SUBMISSIONS REPORT

SSD-8571481 - INSTITUTE OF APPLIED TECHNOLOGY FOR CONSTRUCTION

TAFE NSW

11 JUNE 2021

1 SITE PLAN - PROPOSED - SSDA - PROPOSED ENTRY
SCALE 1:200

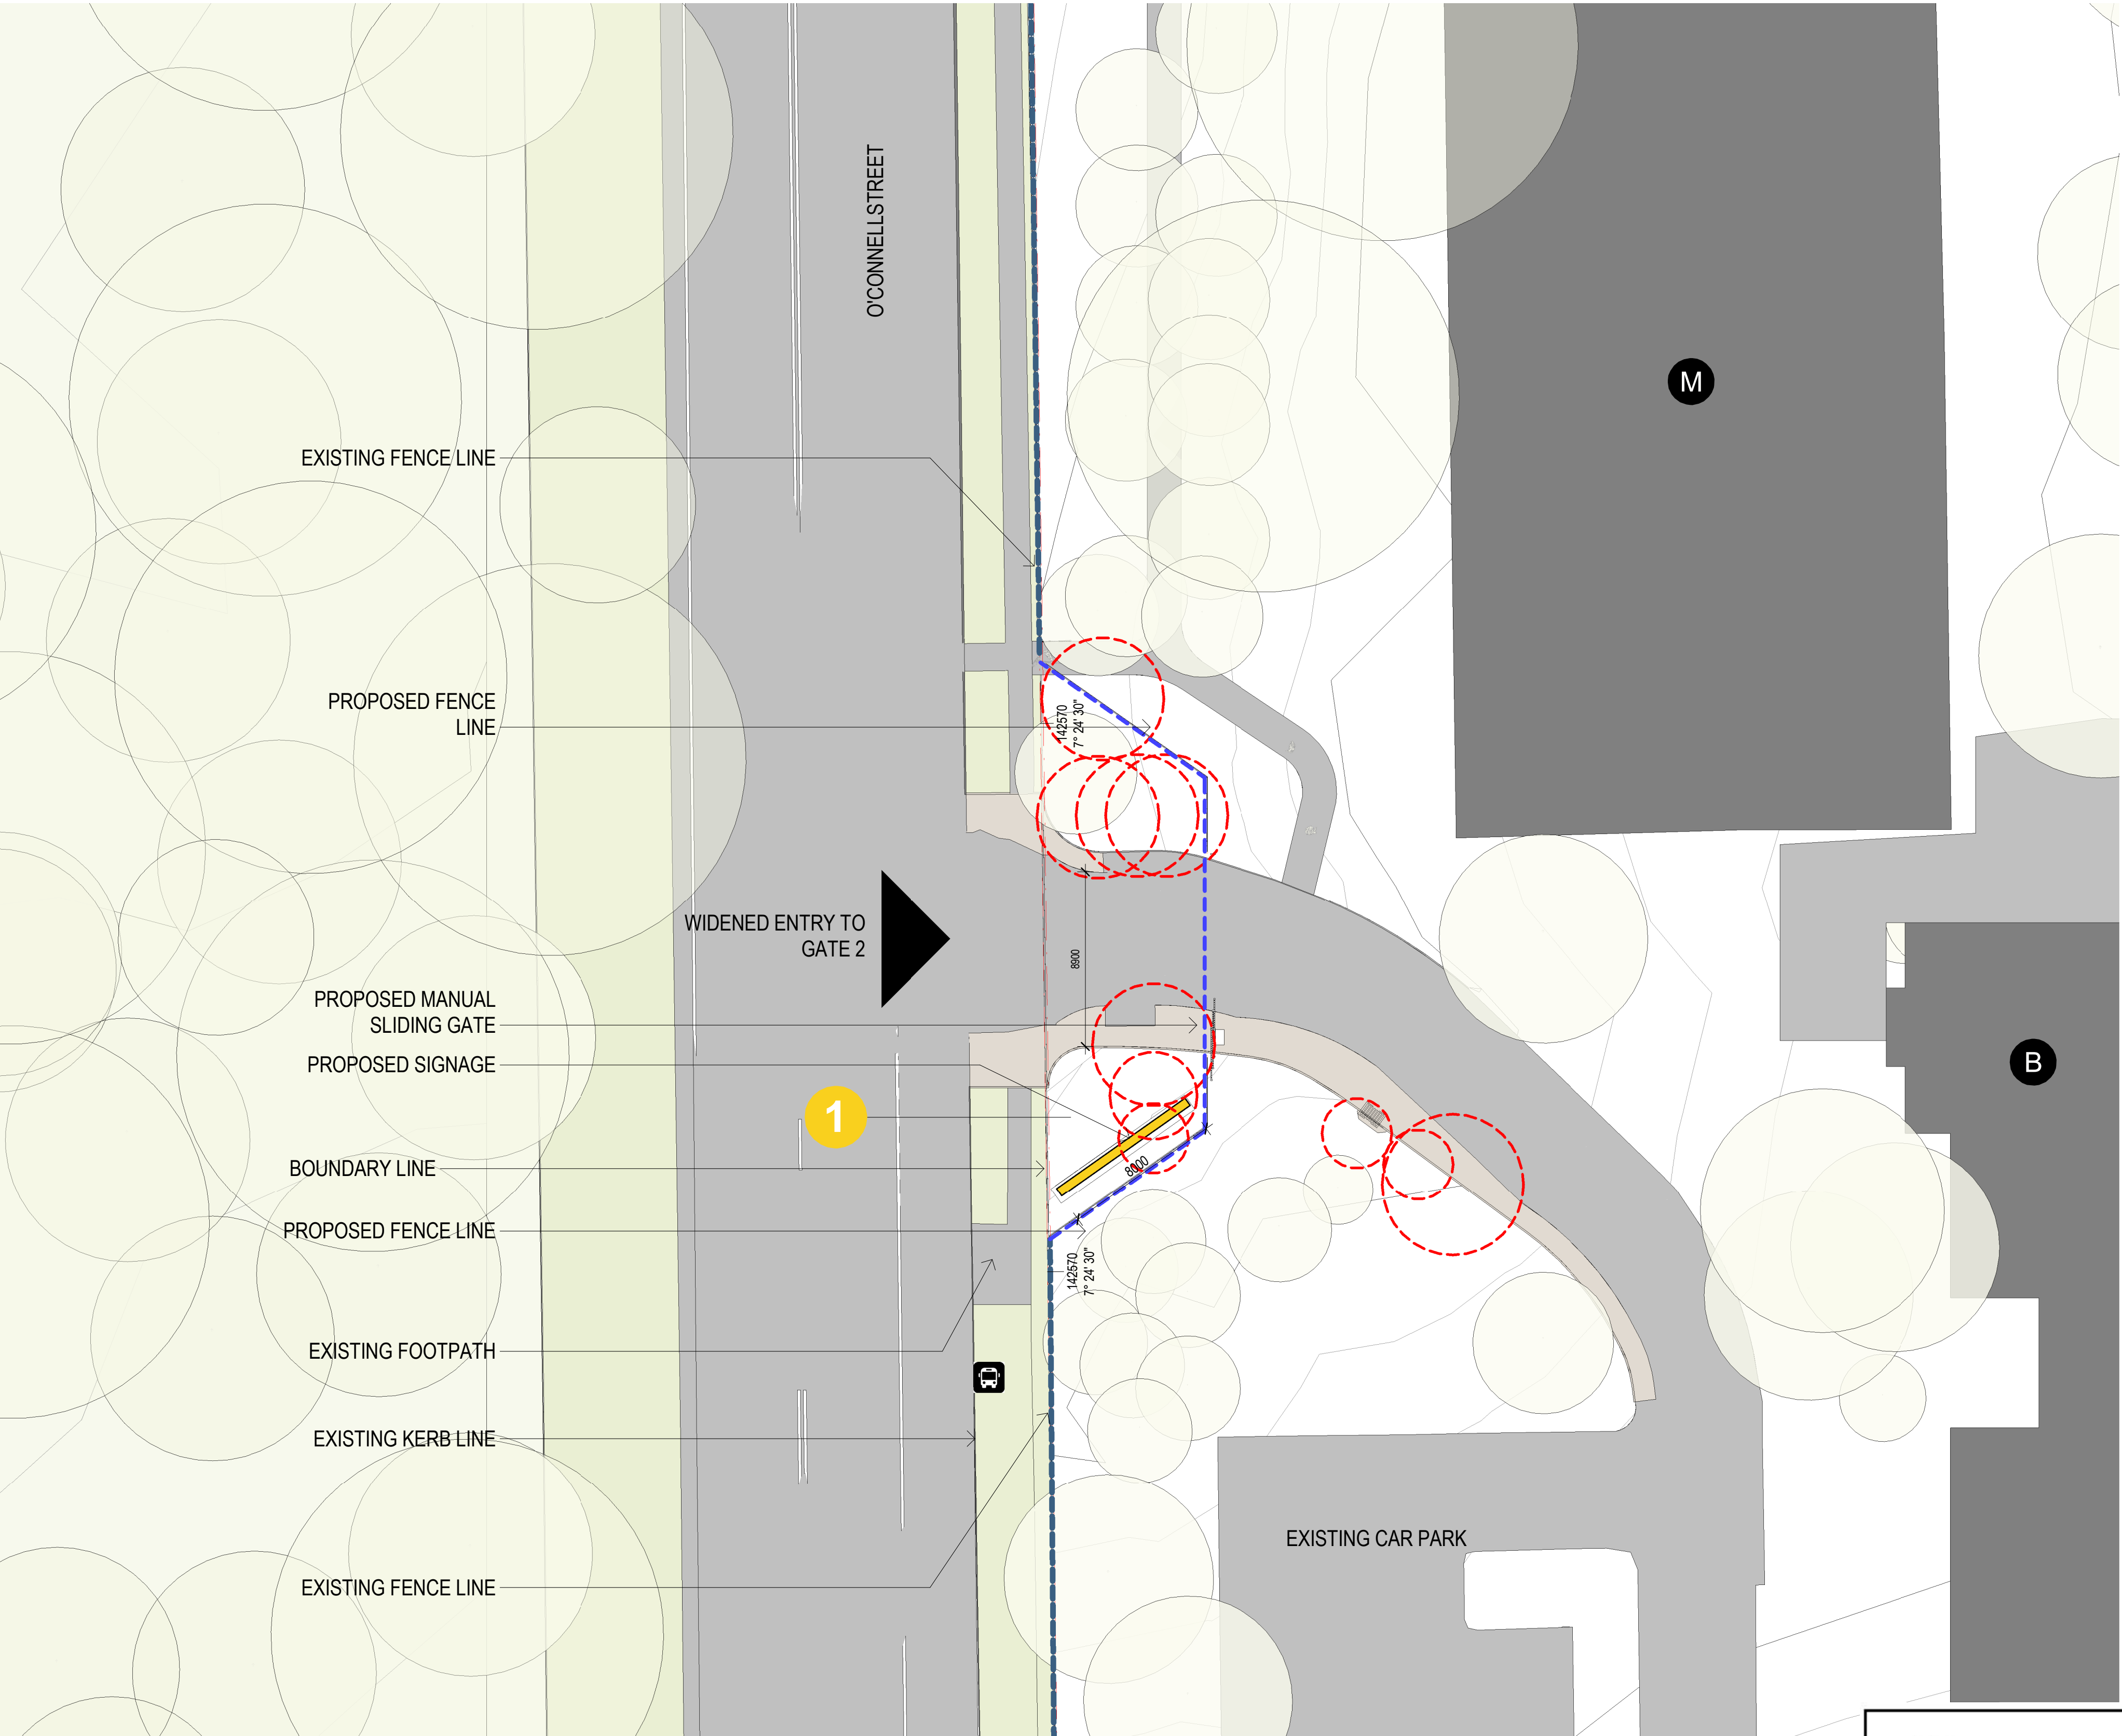
8. Waste Management	All developments are required to provide a waste collection room integrated wholly within the built form to permit a safe and efficient waste collection service. The room will need to incorporate infrastructure into its design in accordance with section 3.4 of the ‘Industrial, commercial and mixed-use waste management guideline’ document. At present this has not been included in the development. The plans should be revised to provide for this integrated infrastructure and address the Council’s Penrith DCP 2014 – Waste Guideline.	<p>A nominated waste collection room has been provided on the southern elevation of the building, adjacent to the vehicular loading bay. The waste collection room has an approximate area of 16sqm, which satisfies the spatial requirements of 13.6sqm as identified in the Waste Management Plan prepared by Waste Audit and submitted within the SSDA package.</p> <p>This is consistent with Section 5.3.4 of the Penrith DCP 2014 as follows:</p> <ul style="list-style-type: none"> - Waste collection can occur in the adjacent loading area. As identified in the swept paths provided in the Transport and Accessibility Impact Assessment (Appendix H), vehicles can enter and exit the loading area via forward direction with only one reverse entry manoeuvre required. 	Amended Architectural Plans (Appendix C)

Issue	Referral comment	Response to submission	Reference to information
		<ul style="list-style-type: none"> - The waste storage area will be concealed by the adjacent sliding gate and services area. - Access to adequate hot and cold-water supply is available for washing purposes. - Signposting will be incorporated during detailed design. 	
Environment, Ecology and Science (EES)

DWG #	DA0110	REV	D
SCALE @ A1	As indicated

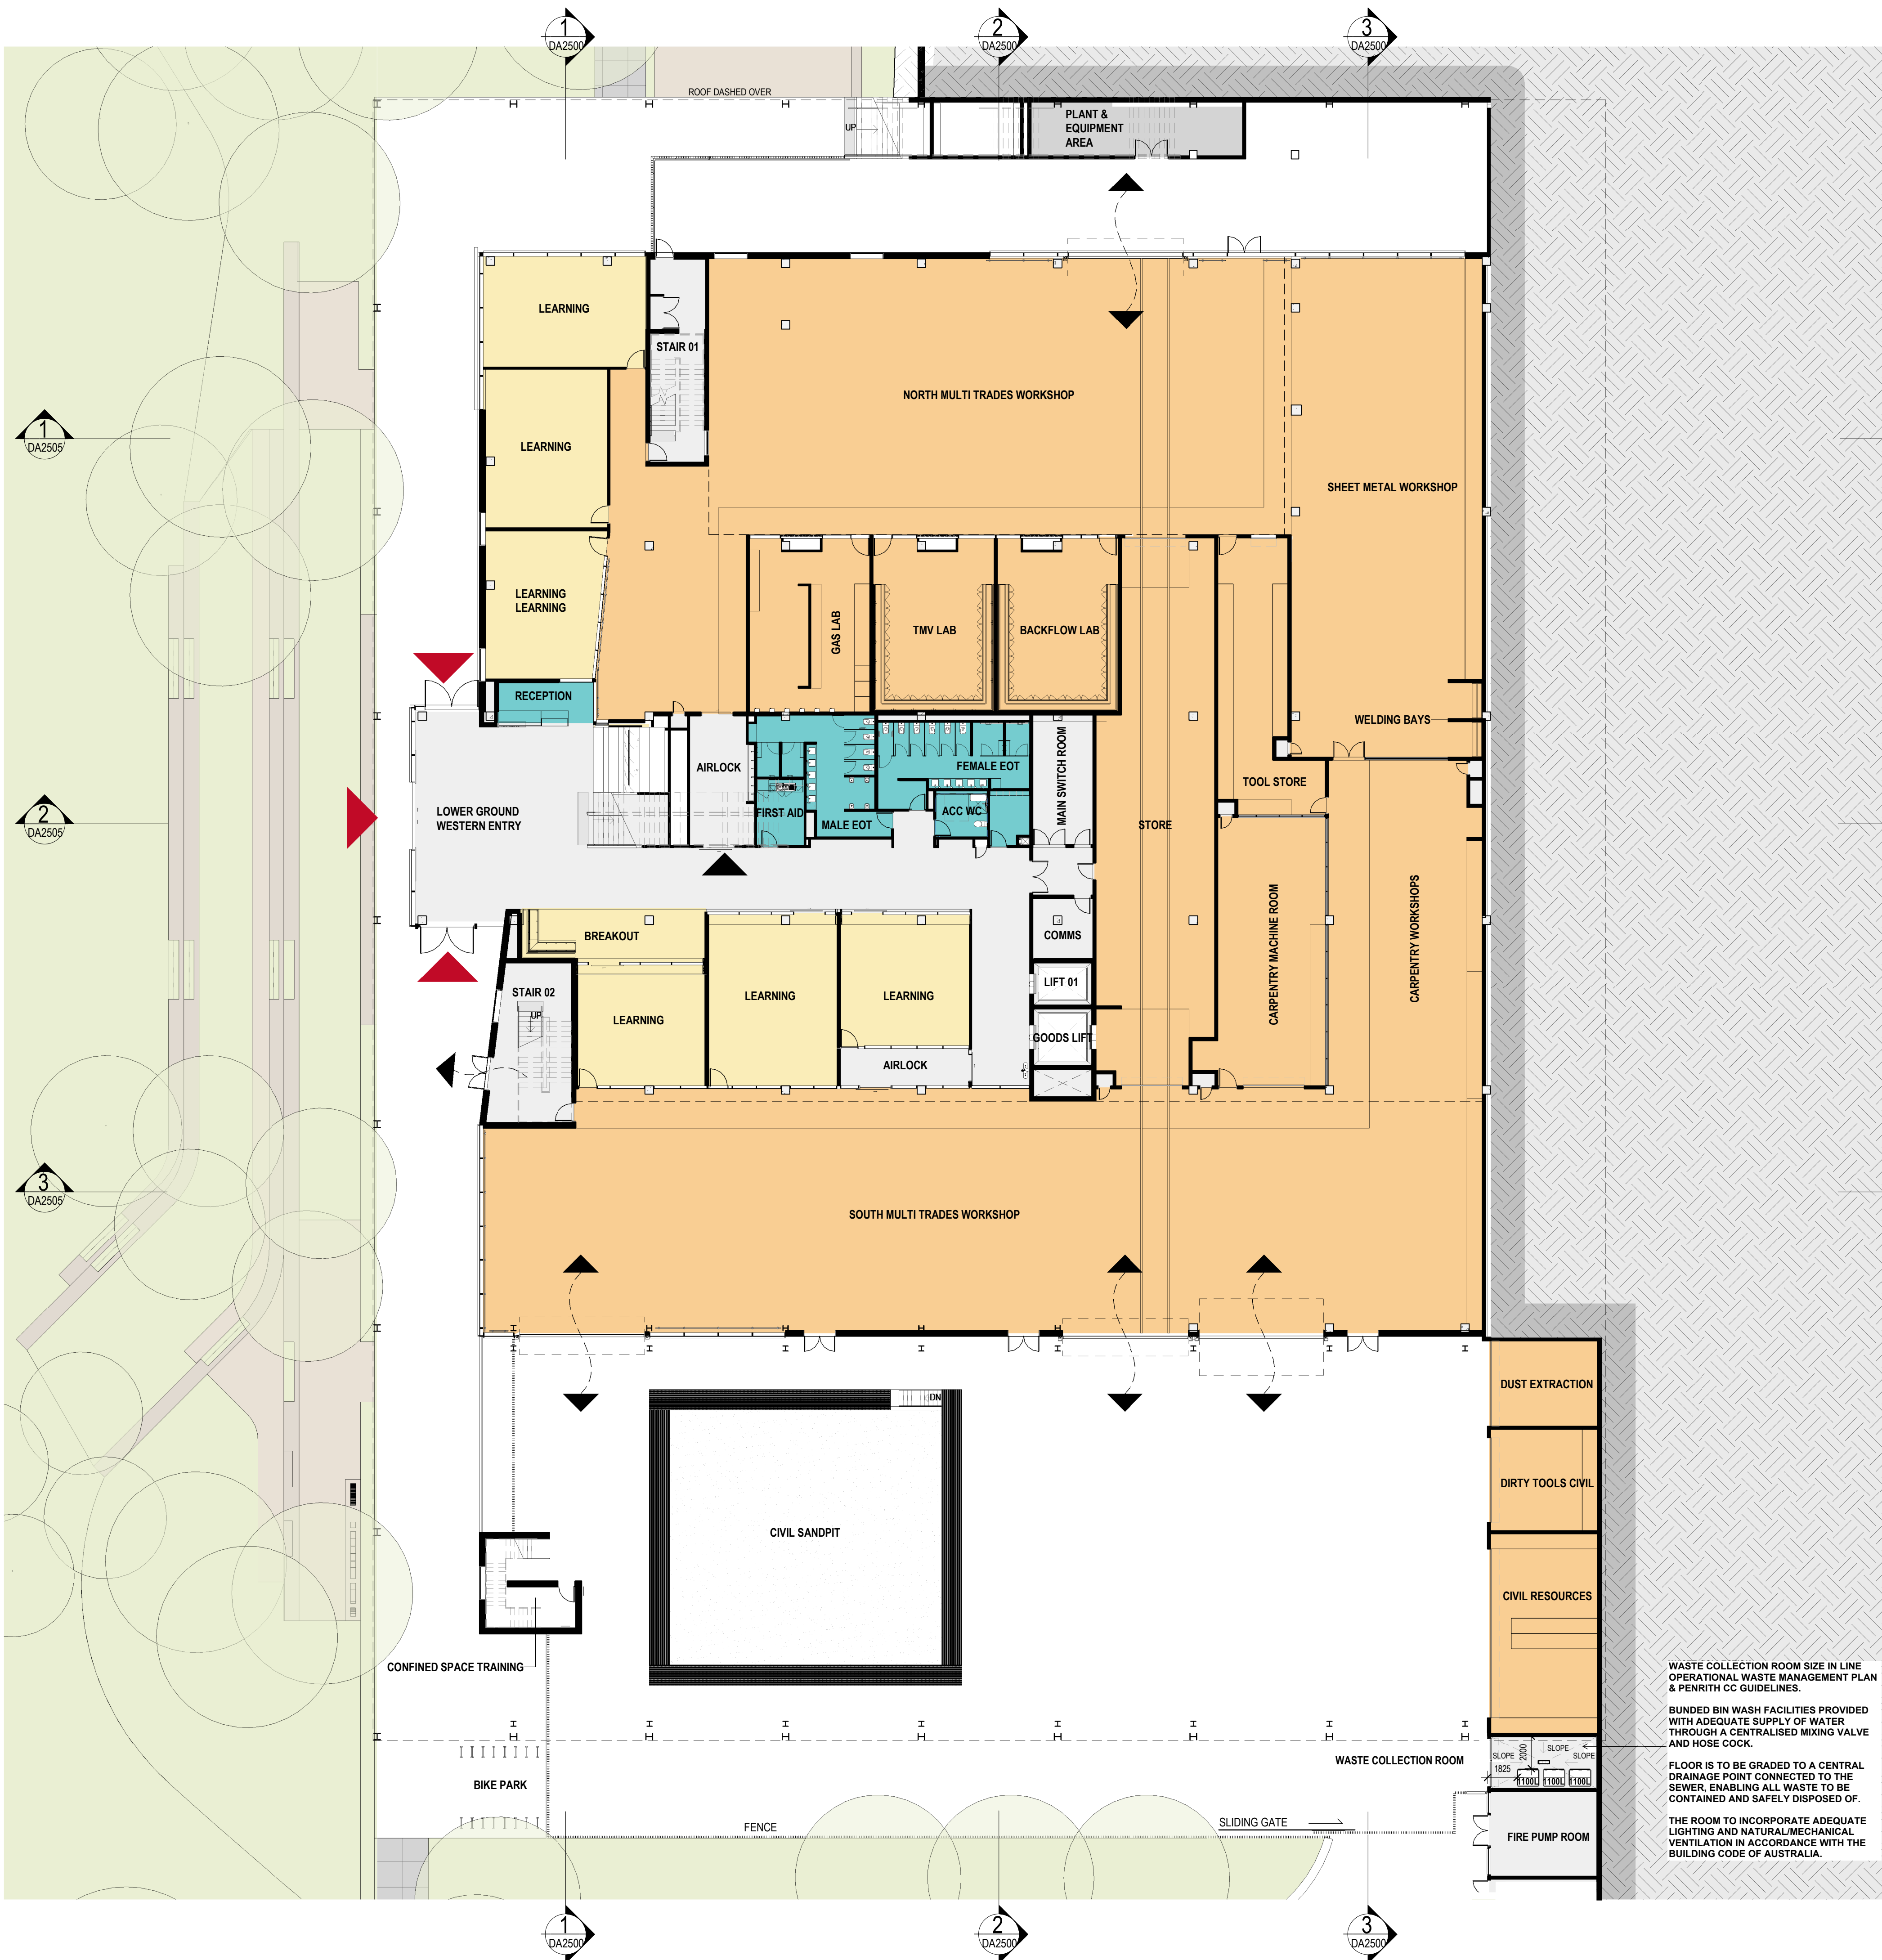
Issue	Referral comment	Response to submission	Reference to information
	<ul style="list-style-type: none"> - modelling of the GWH / Western Sydney University intersection, demonstrating the results of the intersection performance during each stage of construction work. 	Modelling of the GWH / Western Sydney University intersection is provided in the Preliminary Construction Traffic and Pedestrian Management Plan (CTPMP) (Appendix J). The analysis demonstrates performance of this intersection during the construction period will not reduce the level of service or cause an increase to the level of delay.	
	<ul style="list-style-type: none"> - additional evidence to demonstrate that the swept paths of construction vehicles can be achieved without crossing the centreline of O'Connell Street and other internal roads. 	Construction vehicles will not utilise the Gate 2 access on O'Connell Street. Rather, access for construction vehicles is provided through the adjacent WSU site, via a signalised turn off on Great Western Highway. Notwithstanding this, updated swept path analysis has been appended to the Transport and Accessibility Impact Statement (Appendix H). This analysis demonstrates the largest vehicle requiring access to the site does not cross the centreline of O'Connell St.
